Ref: ck220511- rfi response

Project                    **Alterations and Additions to President Private Hospital (SSD – 10320)**  
At:                        369-381 President Ave 61-65 Hotham Rd, 2-4 Bidurgal, Kirrawee  
Client                    Macquarie Health Corporation  
Project Ref:            MACHEALTH-06

## RESPONSE TO REQUEST FOR INFORMATION

Trees to be retained -1, 7, 12(trunk), 18, 23, 29, 31, 32

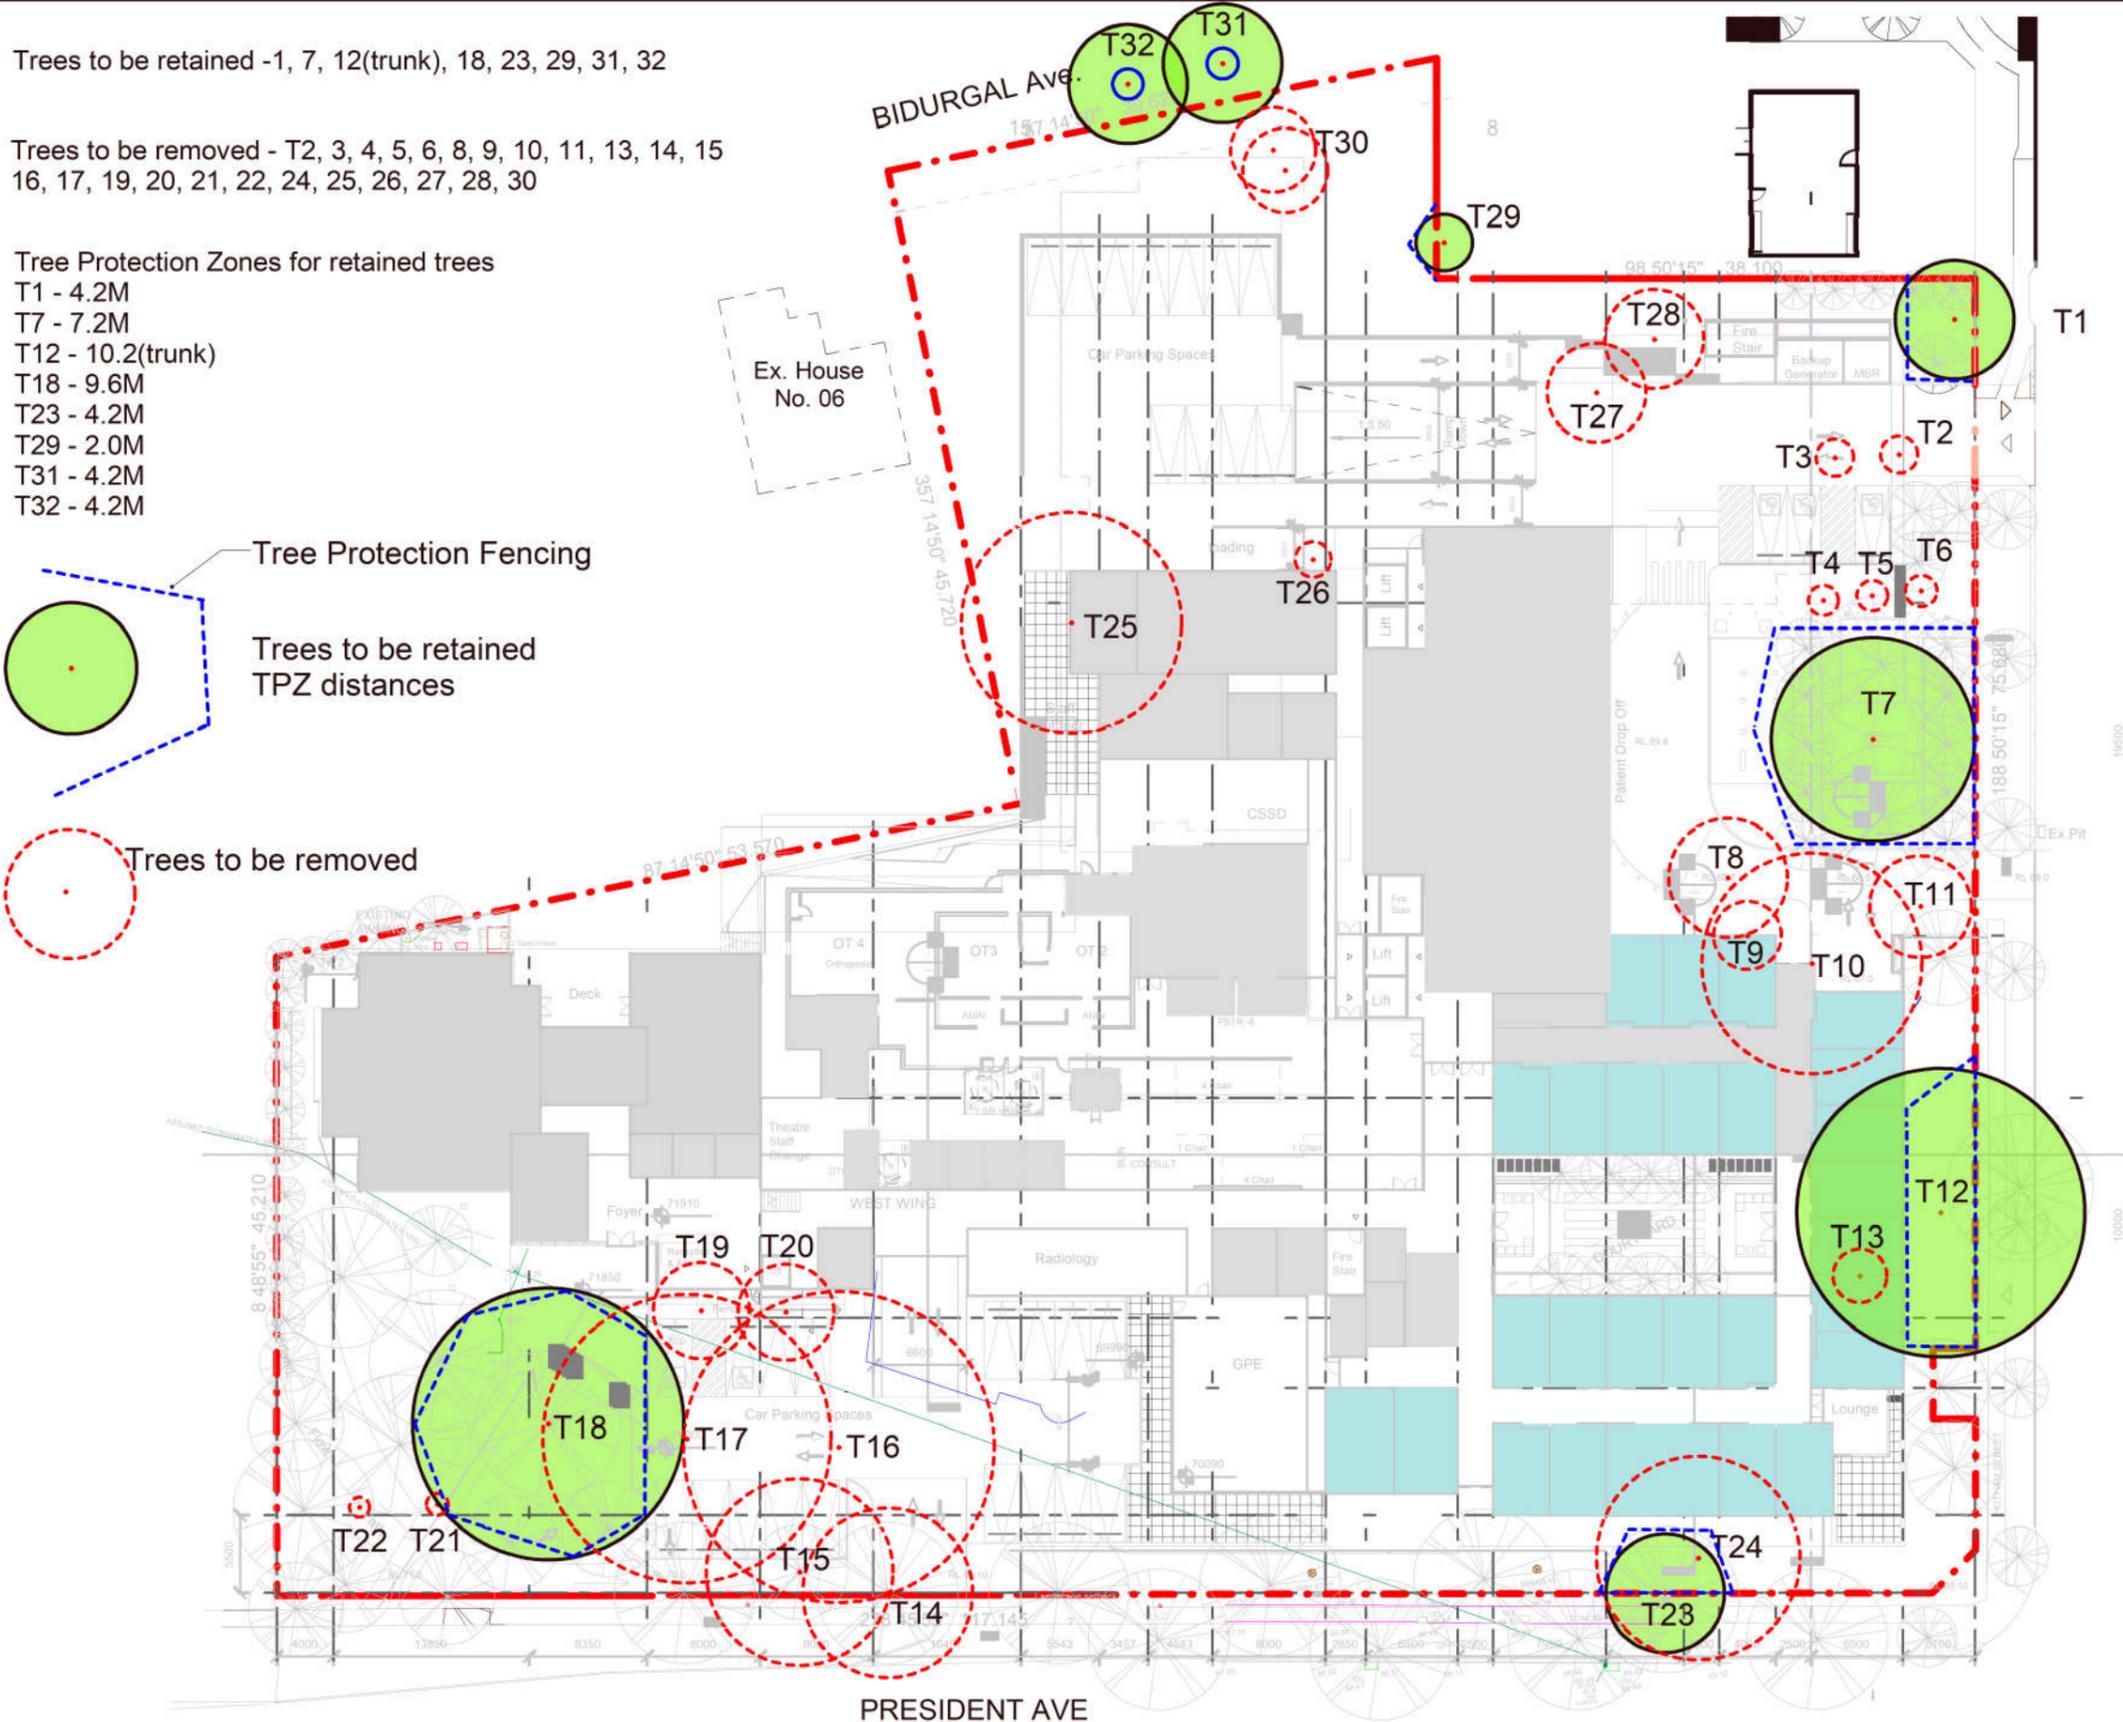
RFI		Proponent's response
	<p>Appendix 7 of the EIS identifies that T23 should be retained and tree protection measures will be implemented.</p> <p>The RTS states that T23 would be replaced in the current arrangement even though it was identified to be retained. Provide justification for the removal and replacement of T23.</p>	<p>amendment to its status in the RTS and amended landscape plans.</p> <p>Should it now be required that T23 be retained the applicant is agreeable to revert to this.</p>
<p>Plans and documents</p>	<p><b>Architectural plans</b></p> <p>The title sheet of the Architectural plans shows several details that do not match plans and information provided in the EIS such as the number of existing ground floor beds being retained, calculations of gross floor area and FSR calculations corresponding to relevant zoning. Please make the relevant updates as required. The EIS also includes discrepancy as to the Gross Floor Area. Please confirm throughout the document if it is 9,519m2 or 10,922m2.</p> <p><b>Details and finishes</b></p> <p>Please provide details of proposed fencing and retaining walls (including height and material).</p> <p><b>Signage Plan</b></p> <p>Please provide details of proposed signage identifying sign size, location and finishes to support the assessment for signage that has been</p>	<p>Revisions have been made on p17 – Section 2.3 Overview of the Development and p 33 – Section 4.2 Project Detail, in the current EIS. Revisions have been highlighted in yellow.</p> <p>The Gross Floor Area of the Development is 9,519m2.</p> <p>Height of fence and material is noted on the elevations. Confirmation that the fence is face brick to match that selected for the building and minimum 1800mm high or as dimensioned higher on the architectural drawings for particular locations.</p> <p>Retaining walls facing into the proposed development are generally of face blockwork. Retaining walls facing neighbouring properties or roads are of face brick to match that indicated for the building.</p> <p>Details for signage were not a SEARs requirement, however, section 7.3.3 State Environmental Planning</p>
